CITY OF ALBUQUERQUE

February 20, 2013

Re: Casa De La Paz, 218 Yale SE
Grading and Drainage Plan
Engineer's Stamp dated 2-11-13 (K-16/D081)

A1 GRADING and DRAINAGE PLAN

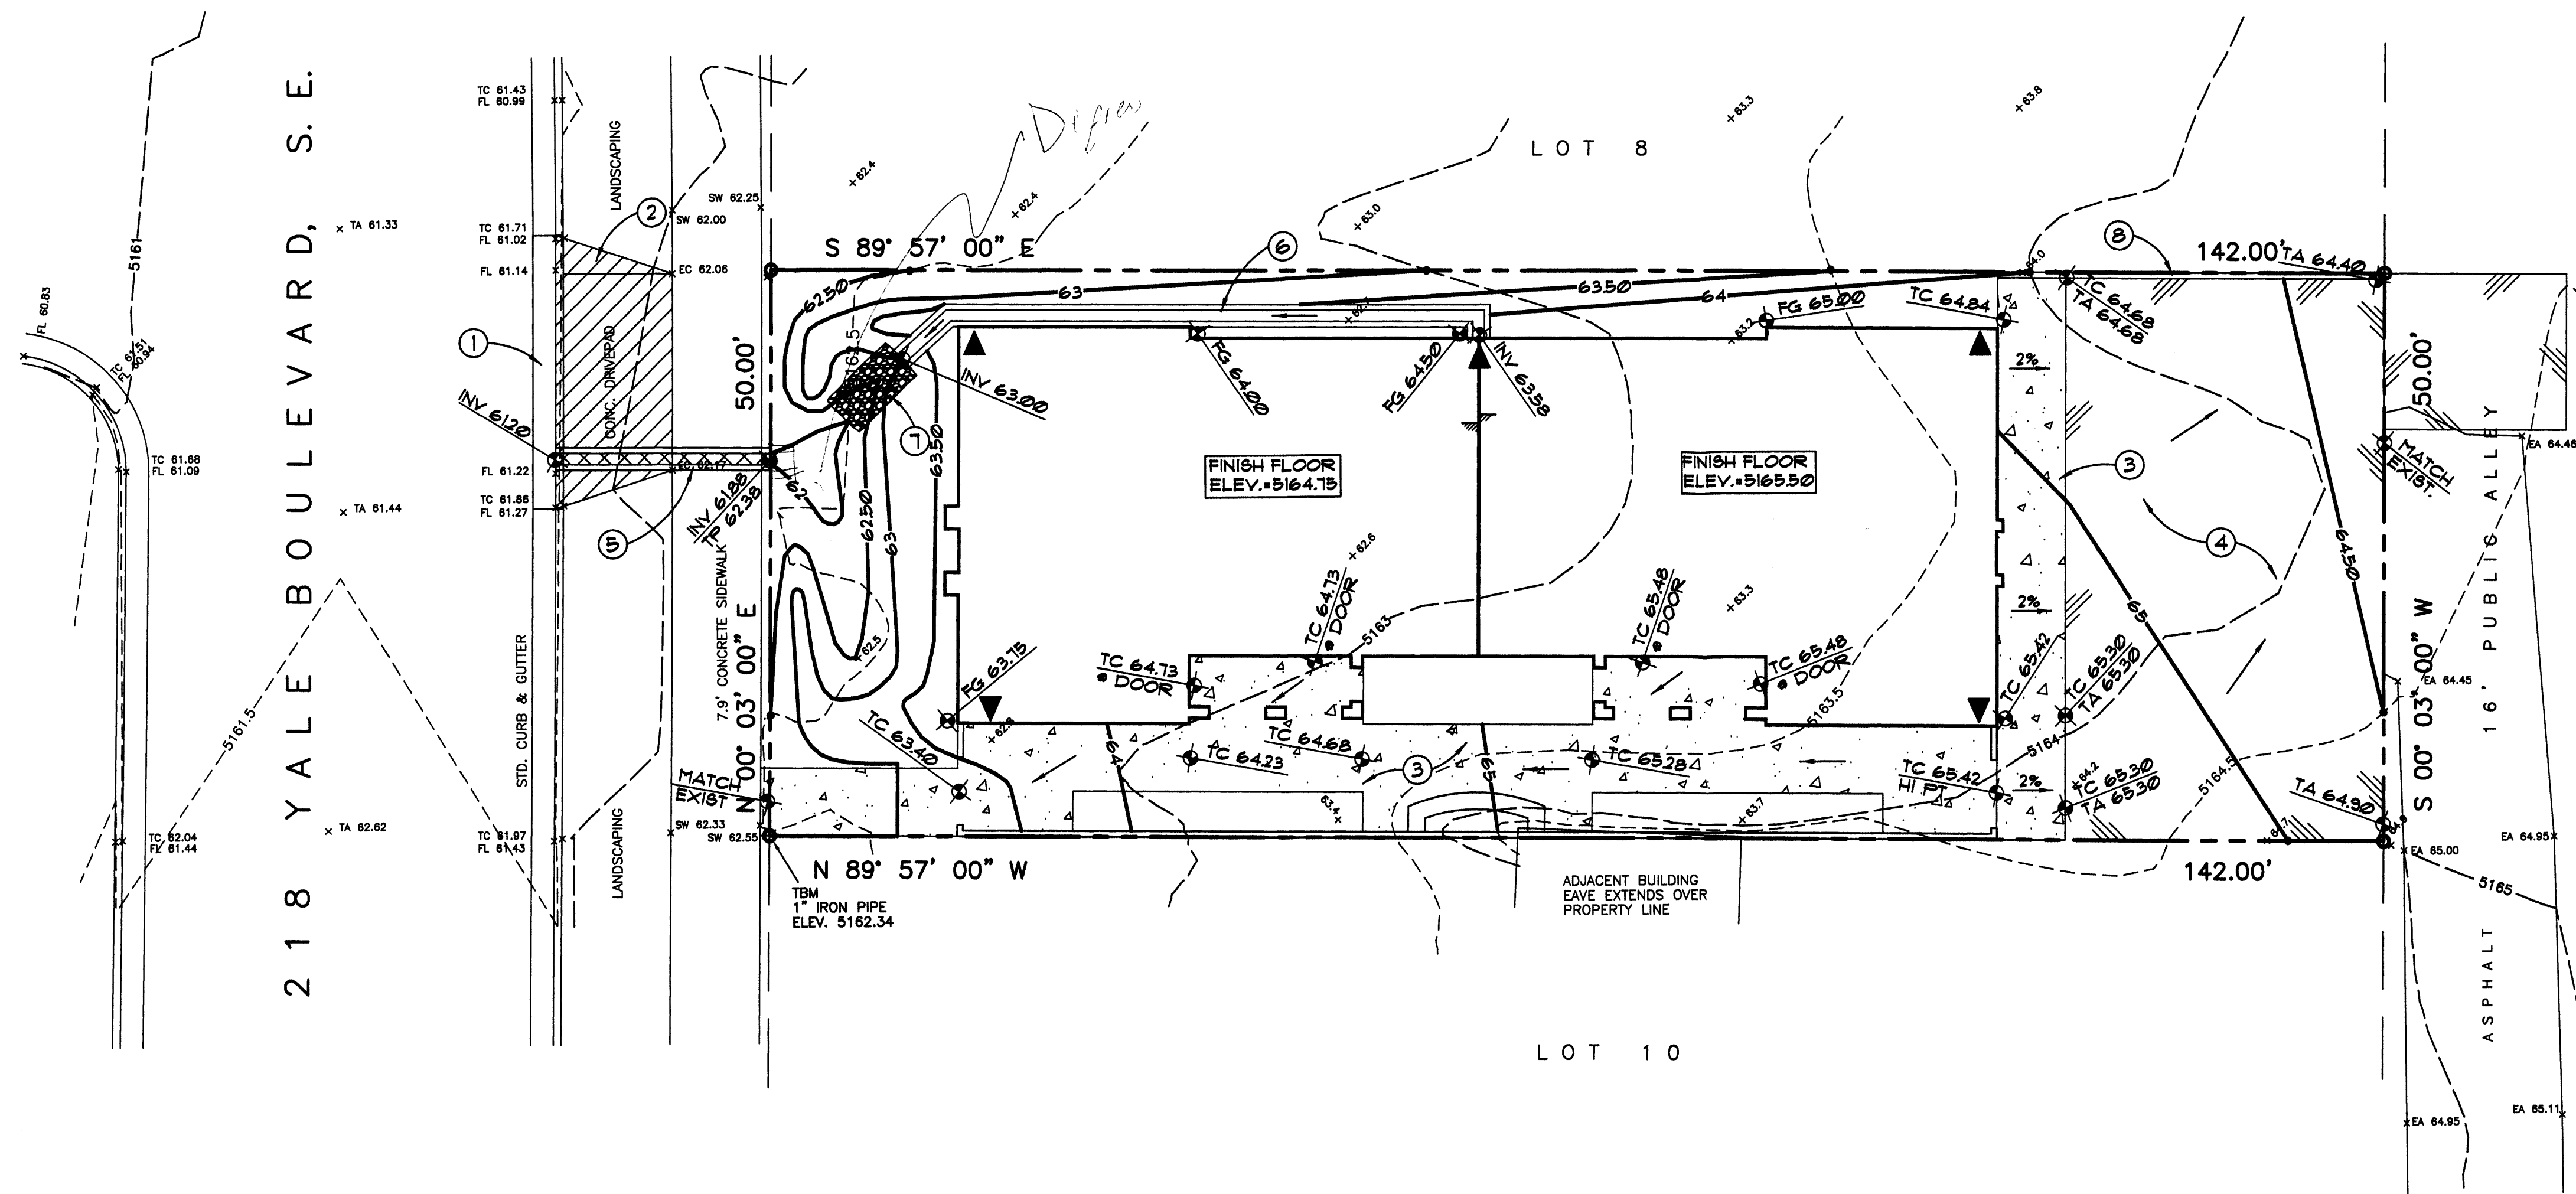
- We would like to see the flows leave the site through the west via the sidewalk culvert and not exit through the public alley. It appears the flows will leave your site and enter the site immediately to the north.
- Extend the sidewalk culvert 2 feet passed the property line and add a note to tack weld all bolts.
- What is the box in the alley with 50.00' in it?
- The alley must be entirely paved.
- A separate permit (SO 19) is required for construction within City ROW. A copy of this approval letter must be on hand when applying for the excavation/barricading permit. Add the SO-19 notes to this plan.
- Hydrology is requesting that proposed landscape areas be depressed to retain/infiltrate the rain that falls on them.
